Levella Residence Revision Letter

PROPOSED DRAINAGE PLAN

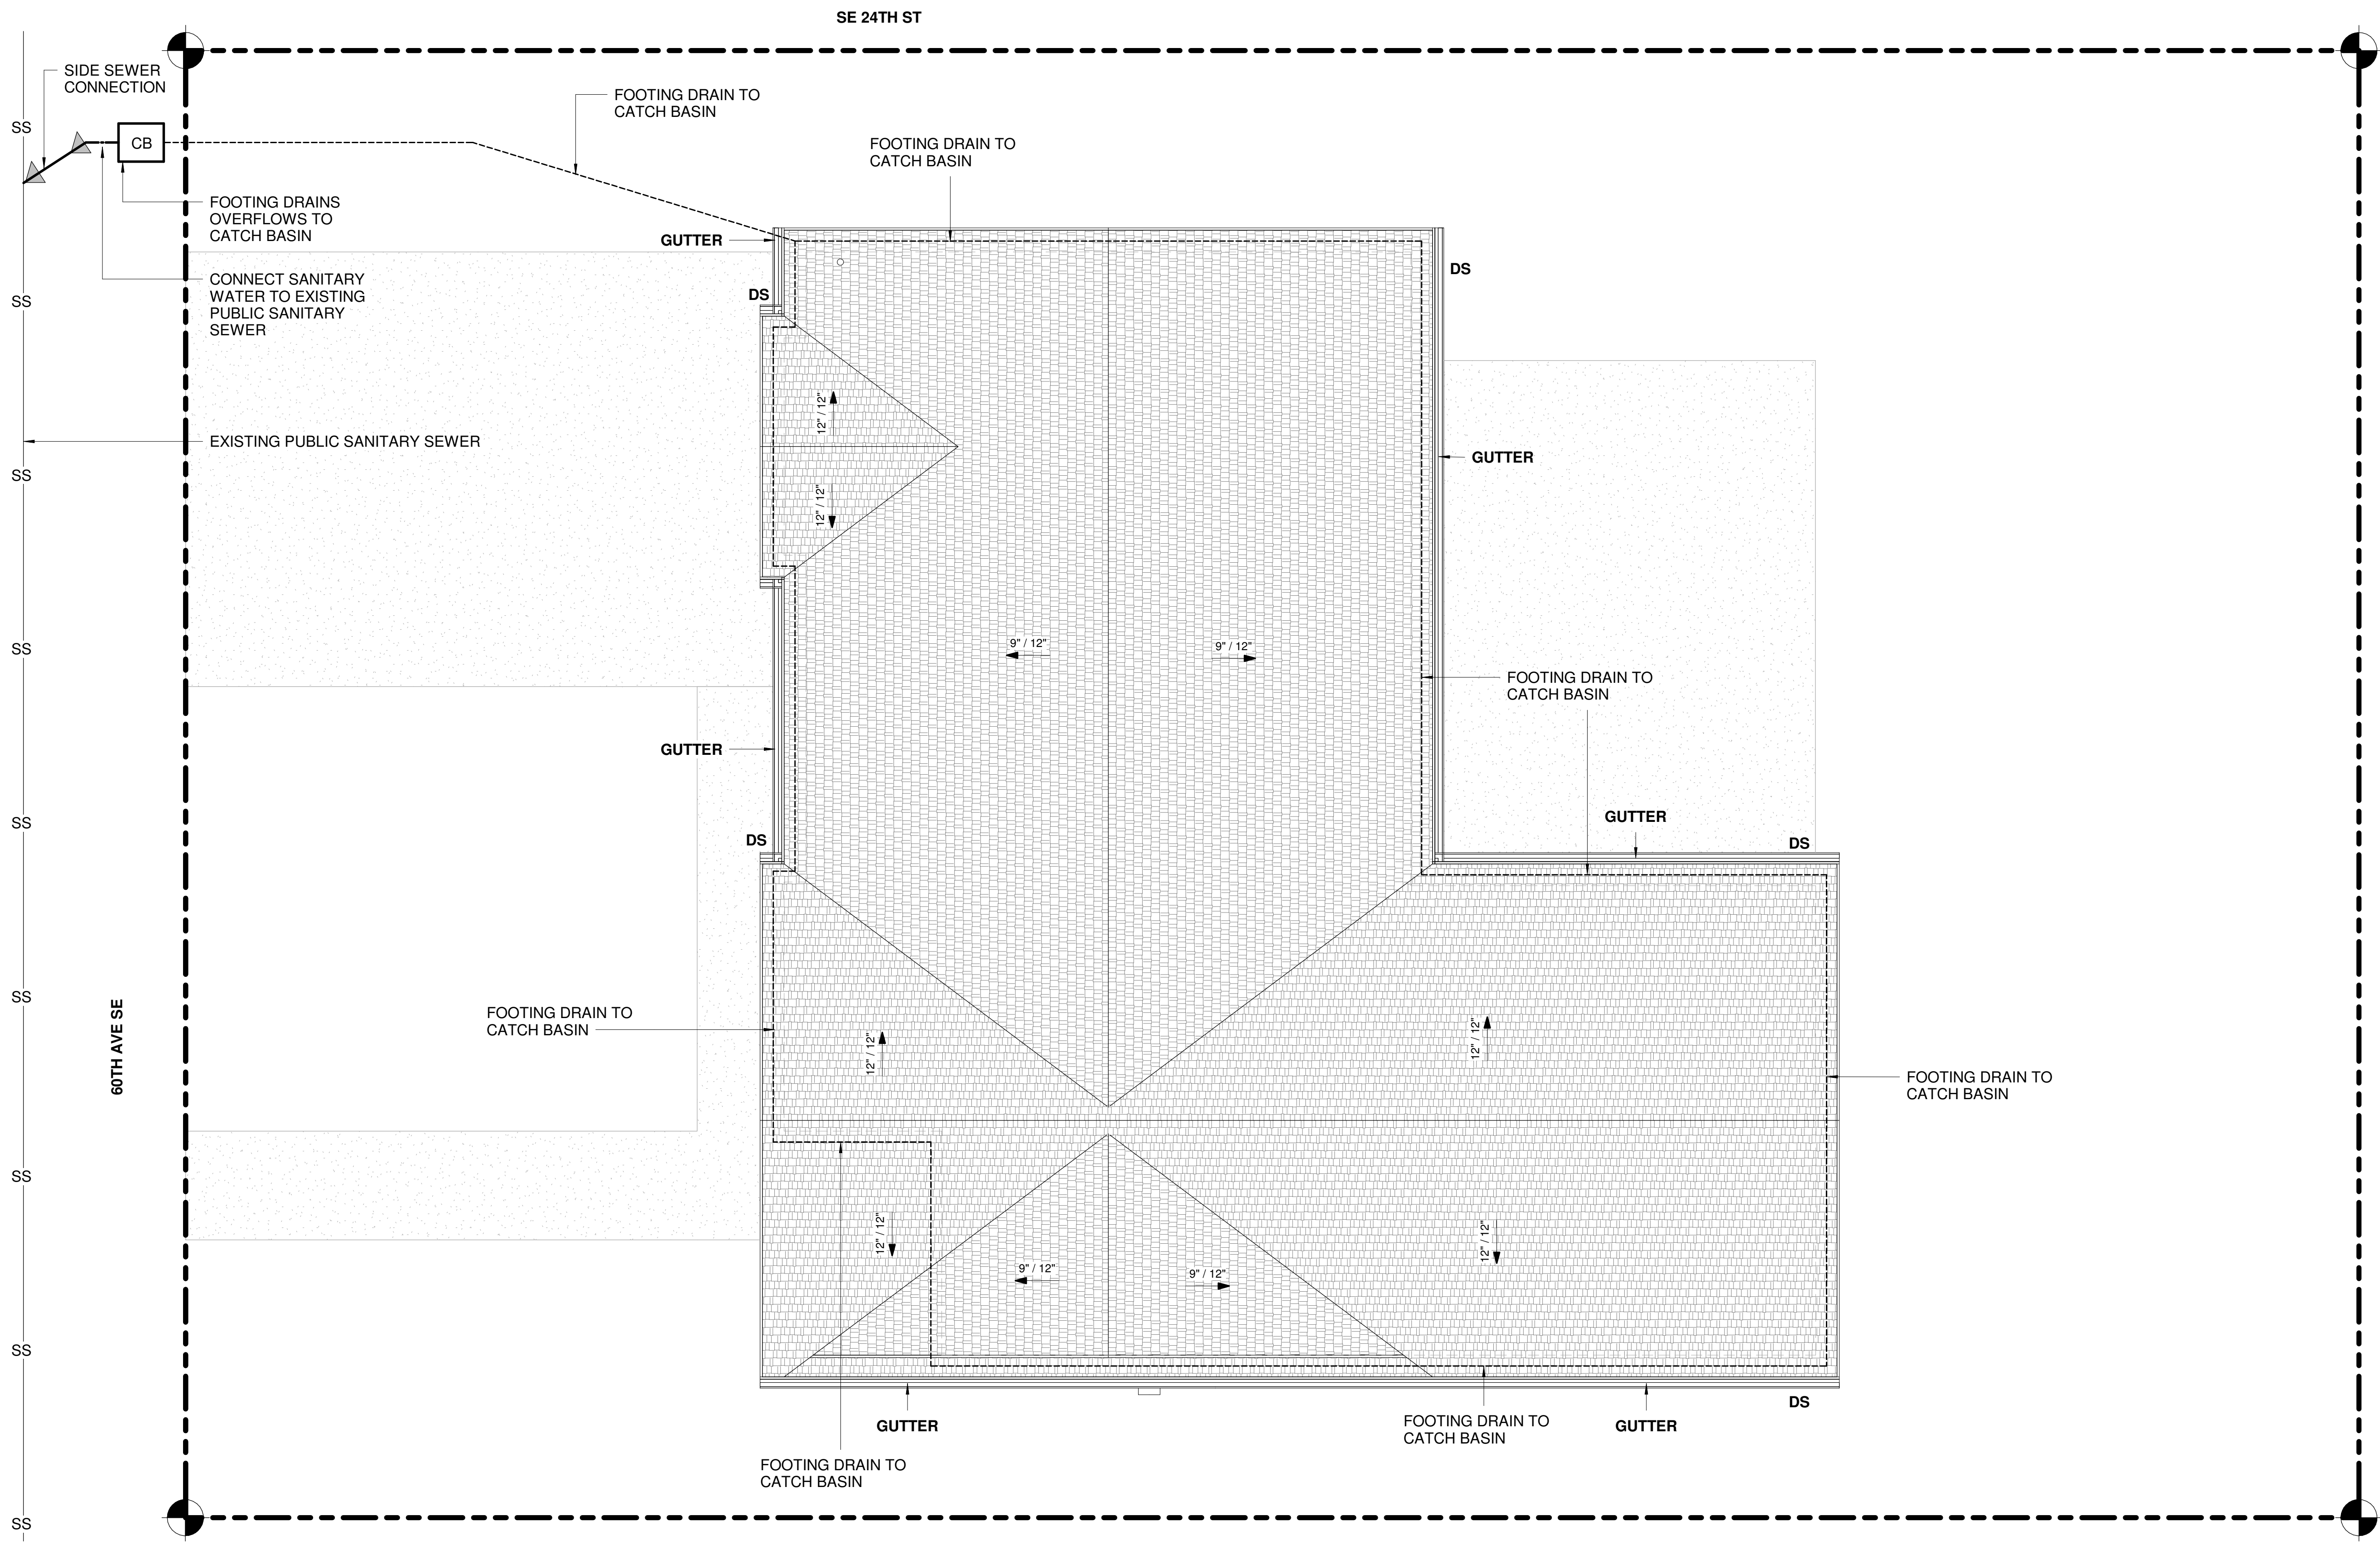
8. The drainage design for the driveway will need to be redesigned to meet the code.

No BMPs are feasible for the driveway, the runoff will sheet flow northwest and be picked up by the catch basin located north of the northwest property corner.
